Harnett County
420 McKinney Pkwy
LILLINGTON, NC 27546
Phone:
Fax:

SUBJECT: SFD2210-0048
SINGLE FAMILY DWELLING

Here are the results of all Inspections located at **1286 CRAWFORD RD:**

Inspection Type: ROUGH IN
Scheduled Date/Time: 2/8/2023
Completed Date/Time: 2/8/2023
Inspector: Scott Guy
Result: DISAPPROVED
Remarks: eTRAKiT Inspection Request
Notes: 2/6/2023 12:35 PM Barefoot Building Company, LLC

Job 3301439	Truss E2	Truss Type Attic	Qty 9	Ply 1	Job Reference (optional)
----------------	-------------	---------------------	----------	----------	--------------------------

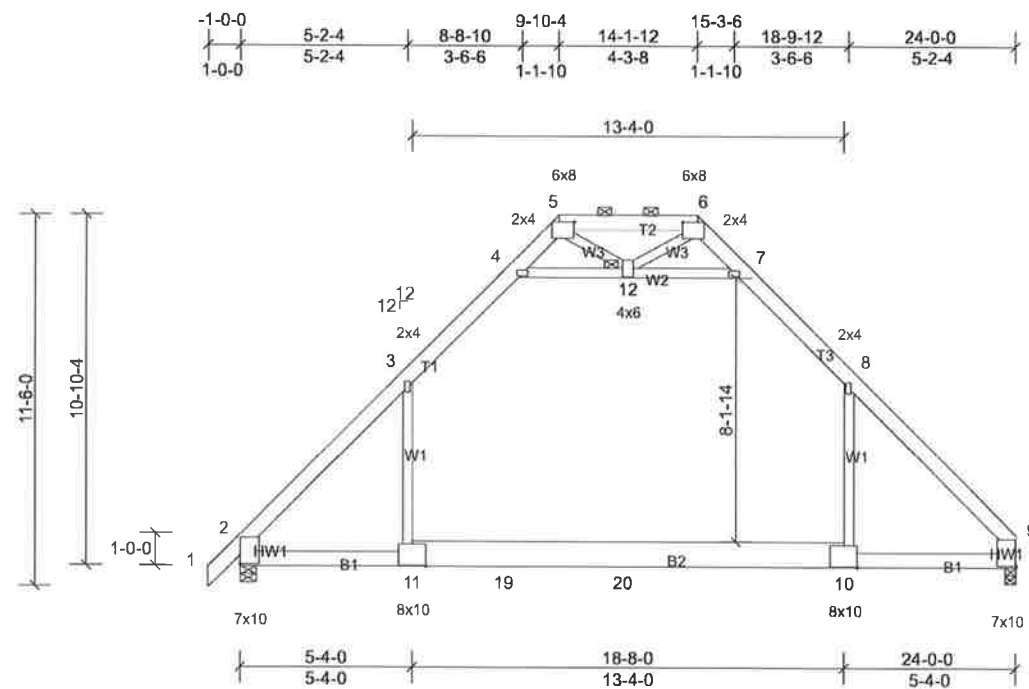
1/ air barrier under stairs missing 2/nail triple stud under two ply truss in garage per code two connections at 12" each side.3/NOTE: washer box is at min height. 4/ install required face nails in all HTU 26 truss hangers though out house. 5/ fireplace not installed 6/appears to be an electrical outlet installed in the rear of the fireplace location. This is allowed only for certain applications. 7/ broken A2 truss in family room.8/front right bedroom triple stud columns are not under two ply girder truss as designed on plans. 9/ engineering letter of repair required for truss directly over bonus room entry door. 9/ broken E2 truss in garage, requires engineer repair and letter.
